From: Amanda Scholes on behalf of Planning.Responses
Sent: 17 October 2019 08:57
To: Planning Scanning
Subject: FW: Planning Consultation on: BE/103/19/RES

Engineers Comments Regarding Surface Water Drainage

APPLICATION NO: BE/103/19/RES

Site Address: Land west of New Barn Lane Bersted PO21 5DN

Plots
As: 3, 5, 11, 12, 16, 20, 27
Handed: 6, 18, 19
Floor Area : 98.35m2 - 1,059 ft2

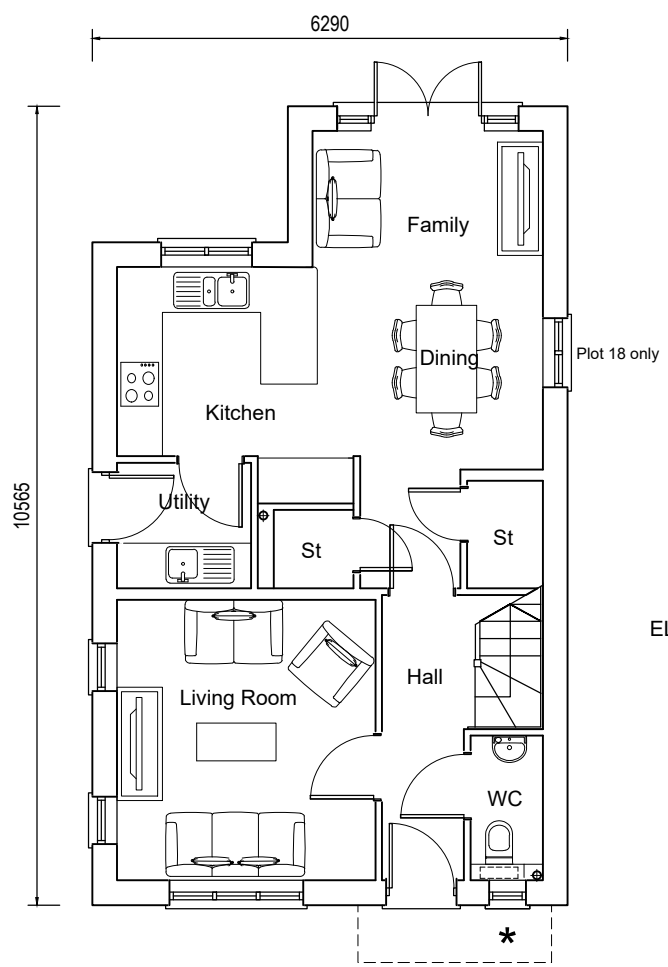
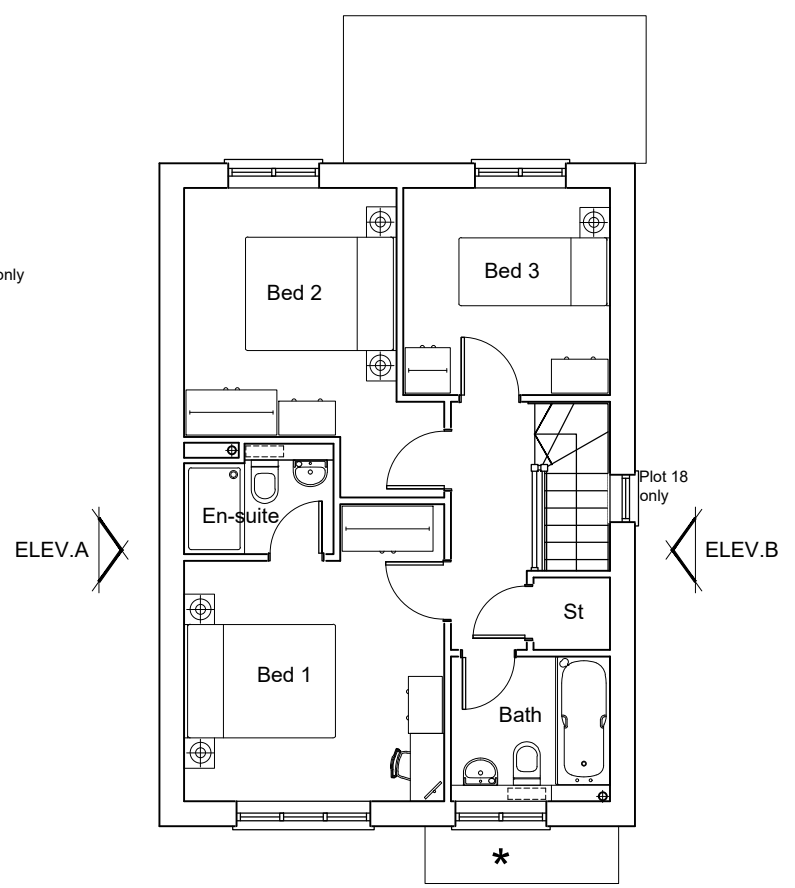
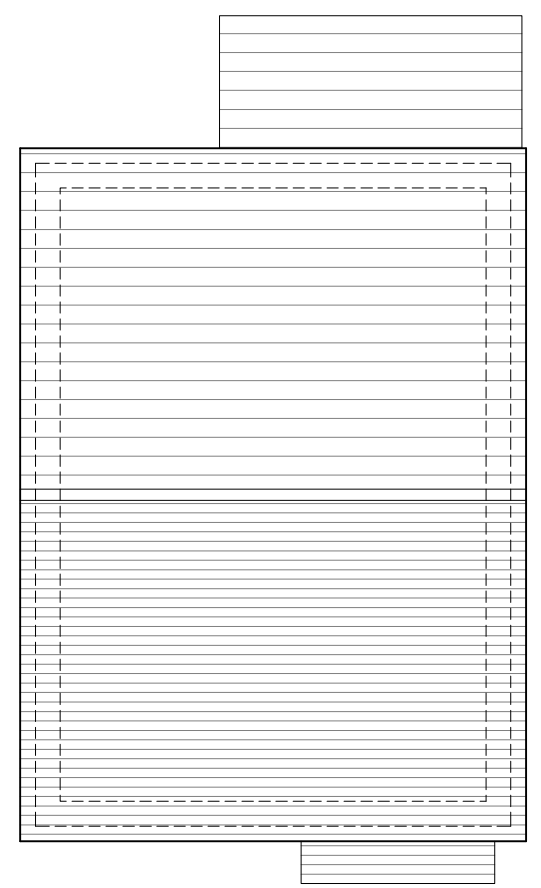
5. There should be a 3m easement from each of the watercourses on the boundaries, in addition there should be a 3m buffer around the detention basin. There appears to be a proposed garage for plots 18 and 19 which is too close to both the watercourse and the detention basin.
